City of Portland, Maine - Building or Use Permit Application

Job No: 2012-08-4777-ALTR	Date Applied: 8/22/2012	CBL: 159- B-026-001	
Location of Construction: 22 ROSEDALE ST	Owner Name: MARGARET PACHUTA & HOLLY HOWARD	Owner Address: 22 ROSEDALE ST PORTLAND, ME 04103	Phone: 207-774-8755
Business Name:	Contractor Name: Matt Hossfeld	Contractor Address: 17 Arlington St., Portland ME 04101	Phone: (207) 272-6999
Lessee/Buyer's Name:	Phone:	Permit Type: BLDG - Building	Zone: R-3
Past Use: Single family	Proposed Use: Same - Single family - build a 12' x 10'8.5" deck with landing & stairs	Cost of Work: 7000.000000	CEO District:
Proposed Project Description: Add deck for Hot Tub		Fire Dept:	Inspection: Use Group: R-3 Type: SB TRC 09 Signature: [Signature]
Permit Taken By: Gayle

has permission to Add deck for Hot Tub

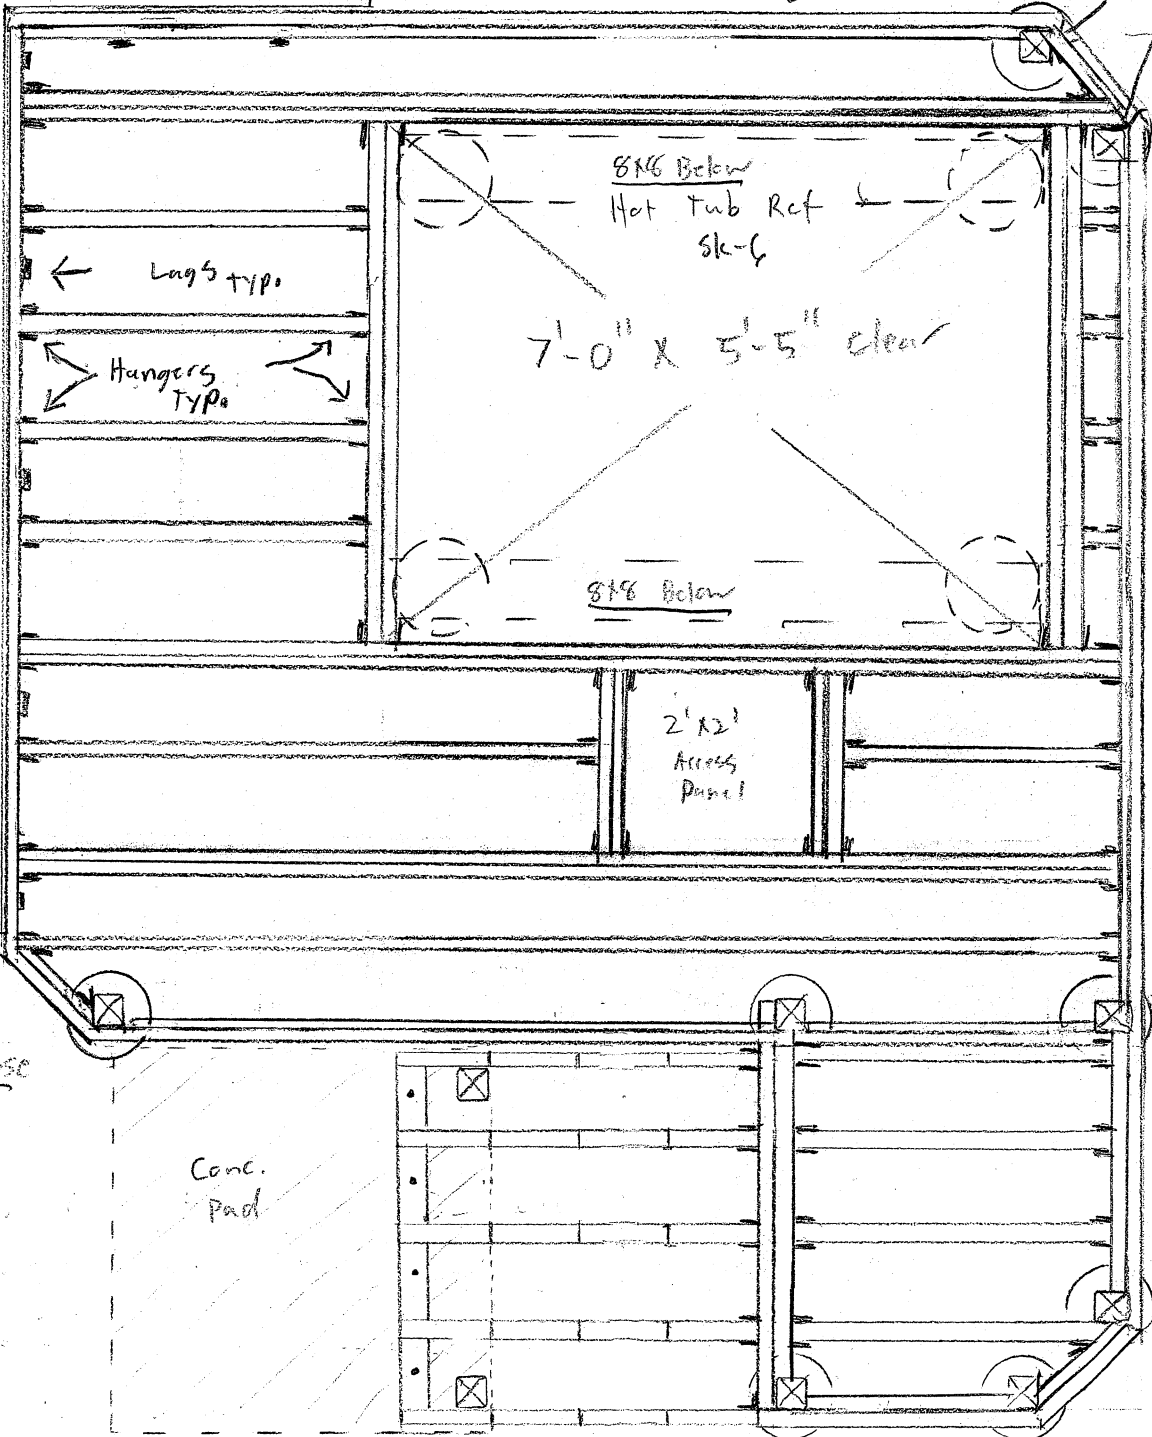
The minimum carrying beam size shall be 2- 2" x 10"-s.

SK-5

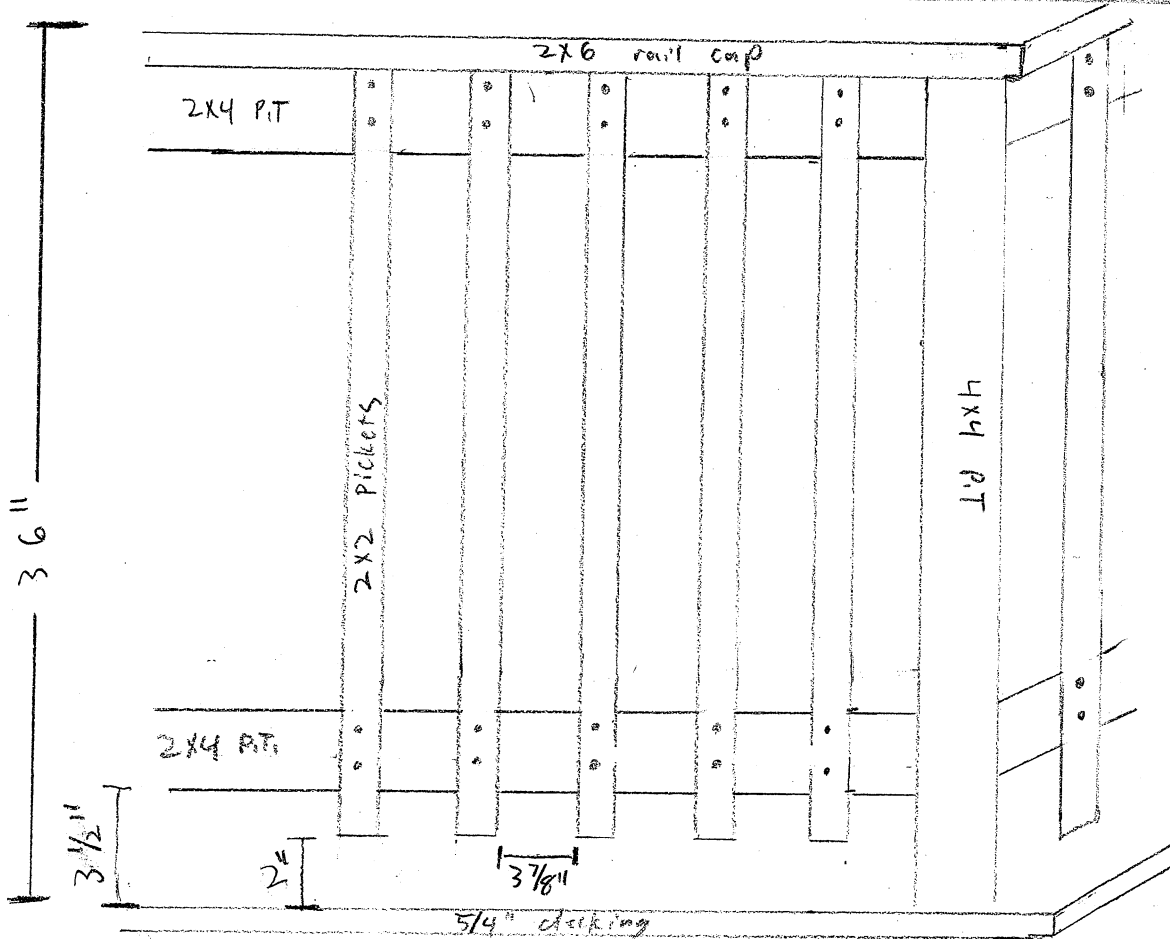
There shall be a graspable handrail on one side of the stairs and it shall return at the top and bottom.
